GOVERNMENT ARCHITECT NEW SOUTH WALES

23 April 2021

PROJECT: Telopea Concept Plan and Stage 1A
RE: SDRP Extended Session – 01 April 2021

Thank you for the opportunity to review the above project. Please find below a summary of advice and recommendations arising from the first design review session held on Thursday 01 April 2021.

# Isolated Sites Study

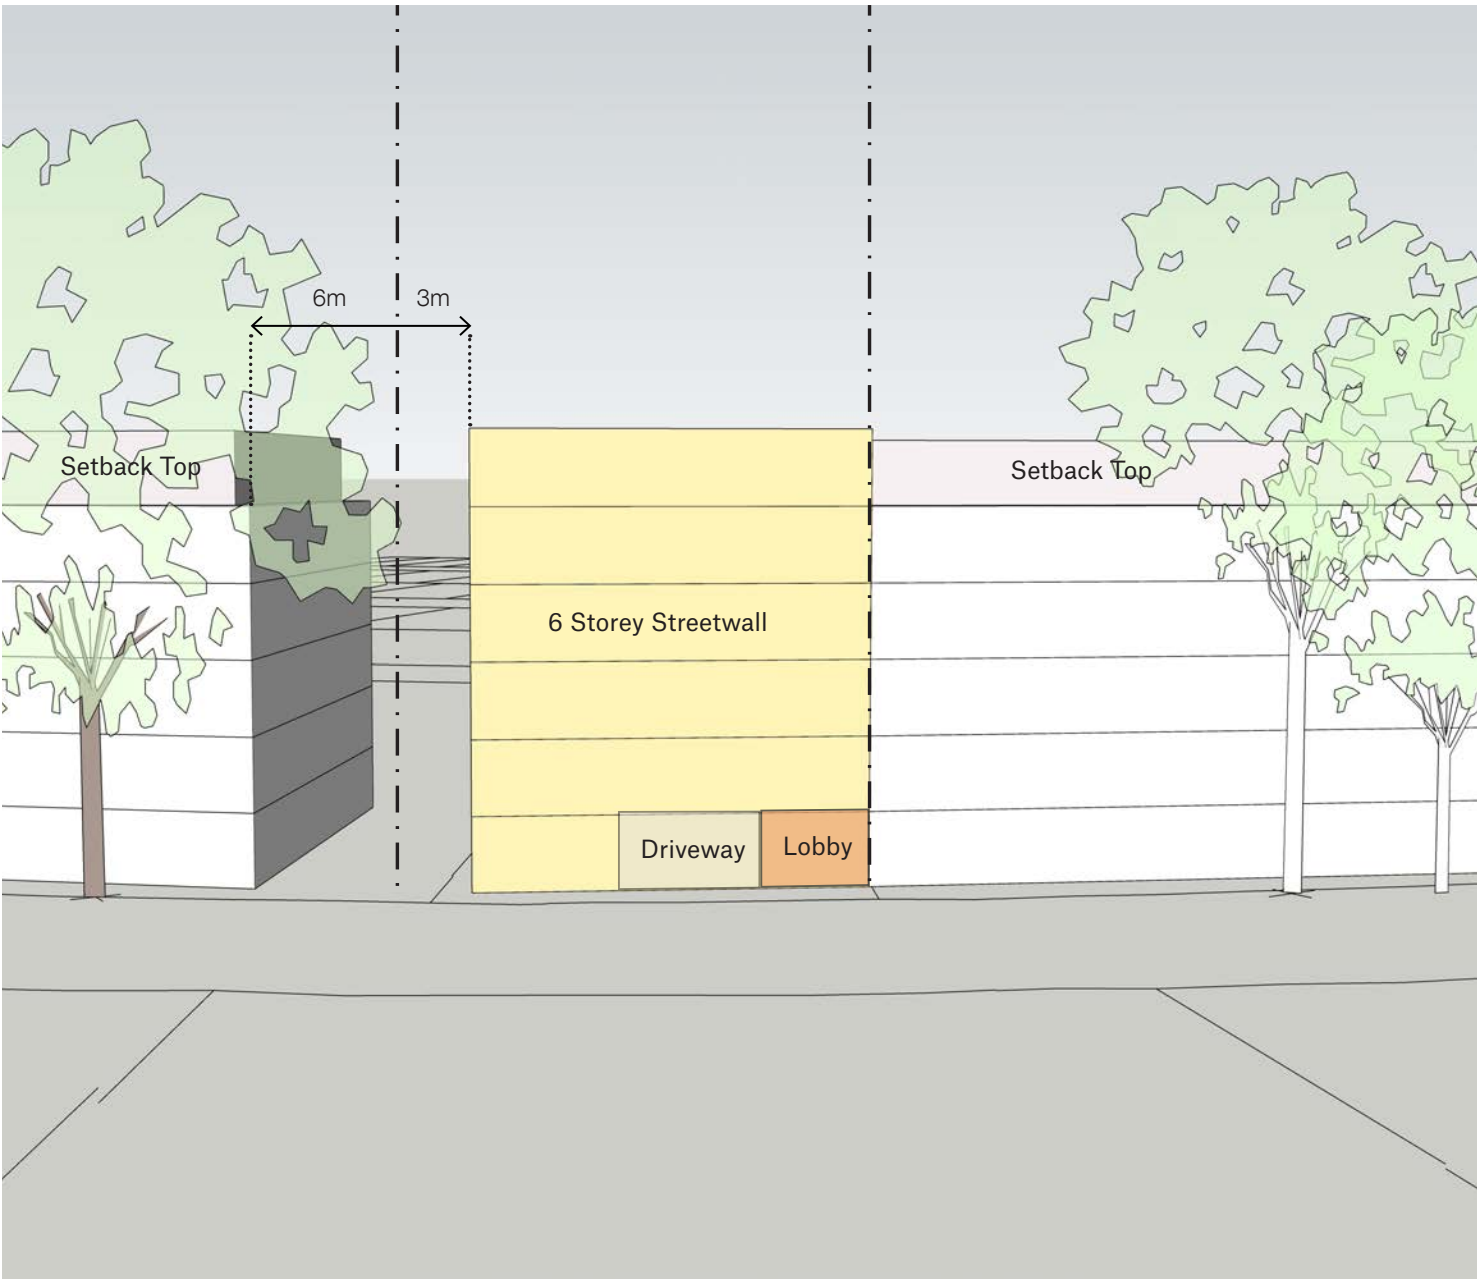
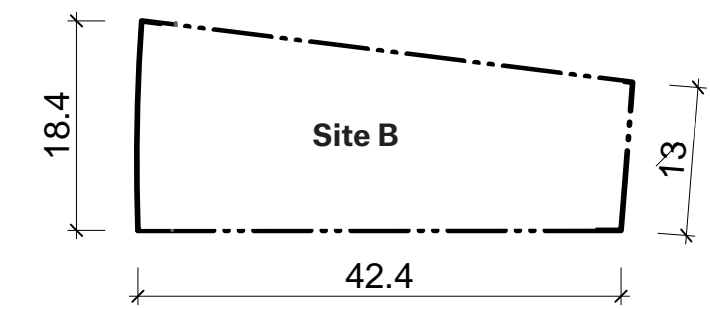
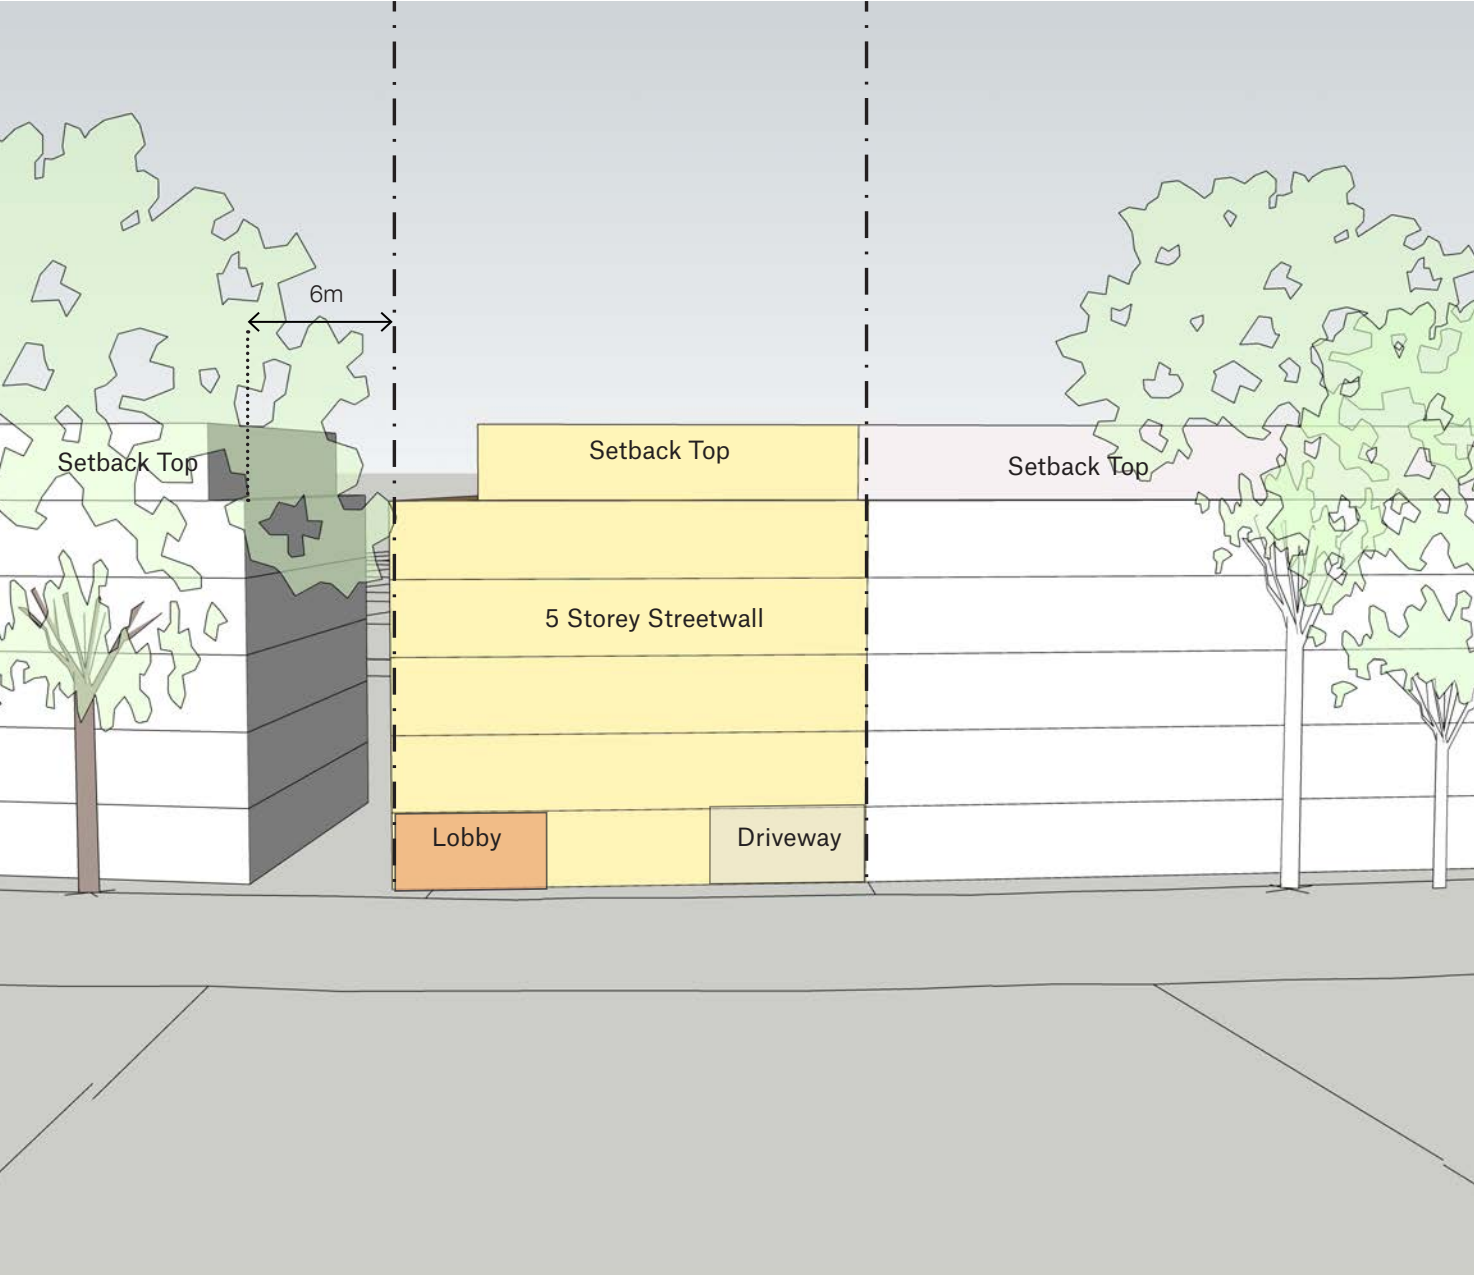
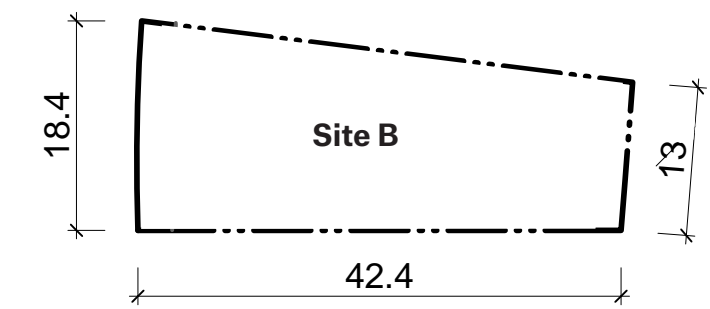
11. Building envelopes at North and South Precincts - the following is not supported for isolated sites, with greater substantiation required;
- setbacks not aligned with the intent of the DCP.
 - height increases beyond Parramatta Council LEP.

DRAWING TITLE
SITE PLAN / SITE ANALYSIS

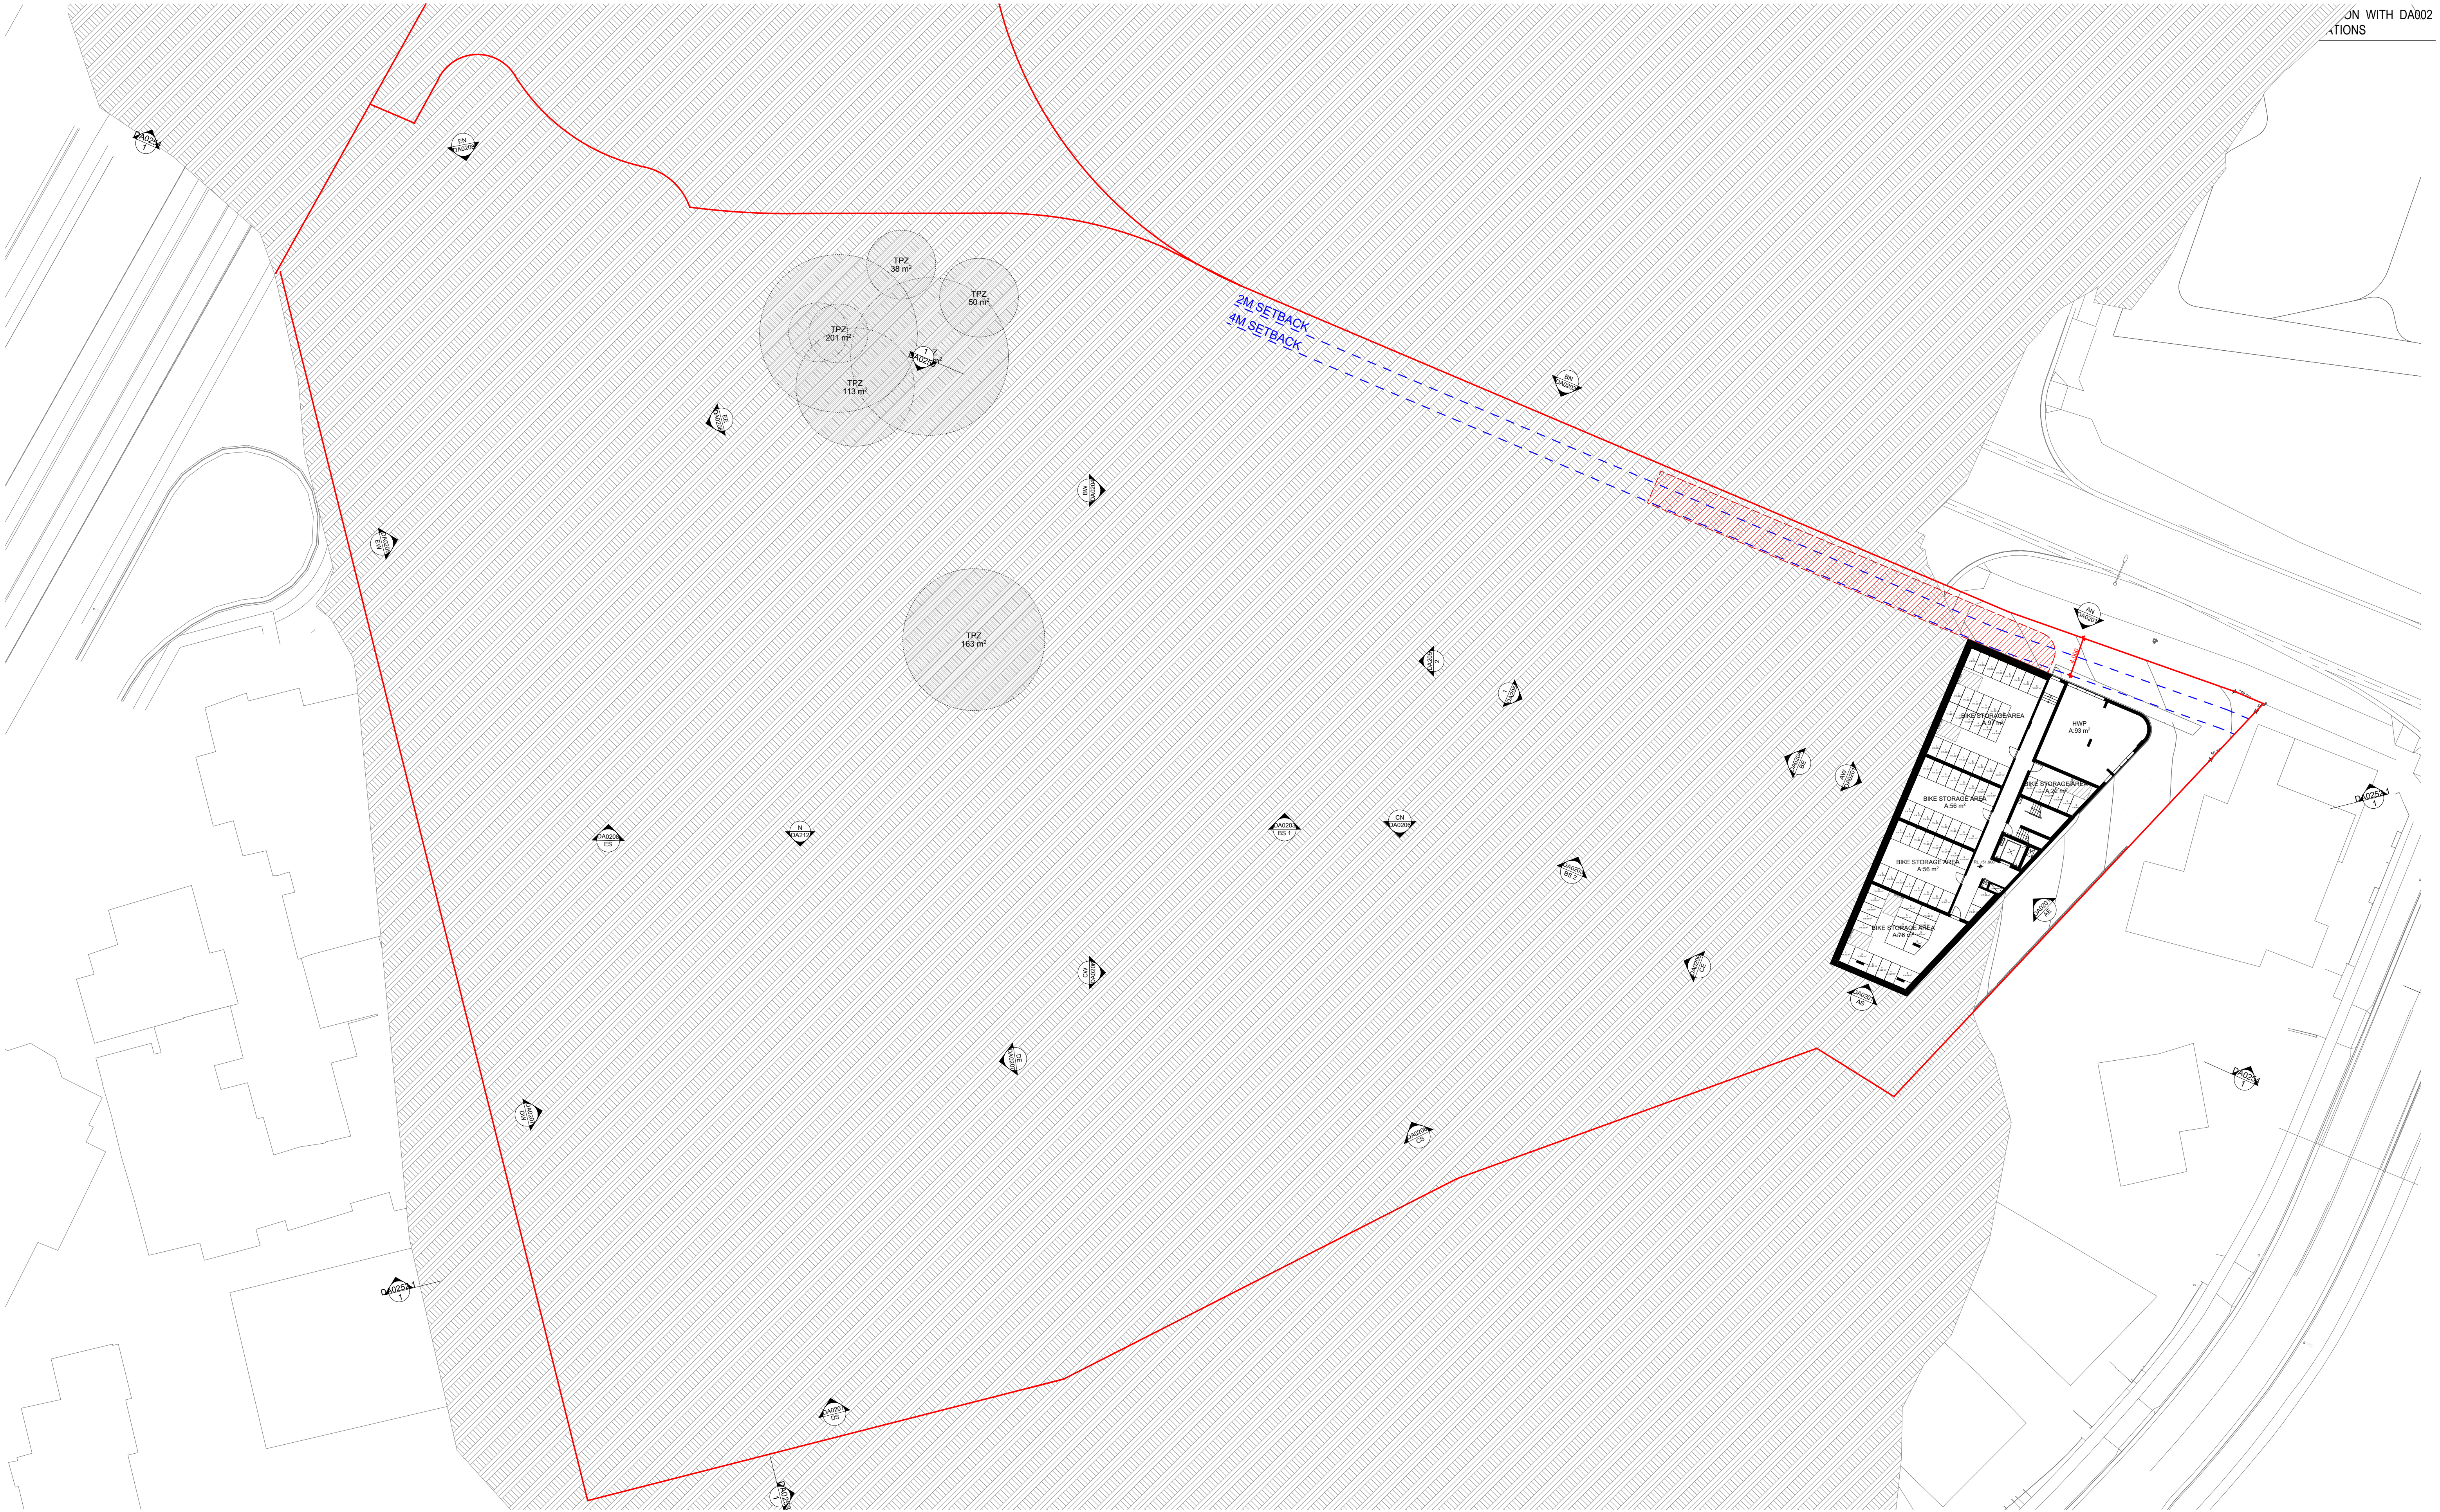
- The current sub-precinct layout is not supported:
 - the site area is too large for the approach taken; the site requires through-site links with proper street frontage to provide suitable access to the developments within the sub-precinct

- the proposed cul de sac is inadequate as a means of providing access to all parts of the sub precinct
 - public open spaces are not legible as such and not welcoming or engaging for the community

- communal open spaces are unsuitable for a wide range of uses
 - building orientations result in a majority of units having sub-optimal solar access.
- Improve connectivity through the sub precinct by, for example, extending the cul de sac to connect directly to the Station plaza. Ensure generous path widths and landscape treatments.

12. Stage 1A sub precinct options for creating through-site connections.	<p>Noted. Fraser's and Plus have now undergone a complete re-design of stage 1A to address the SDRP concerns and improve the overall development.</p> <p>The road aligns with the pedestrian link from the south, reinforcing the connectivity to the station.</p>
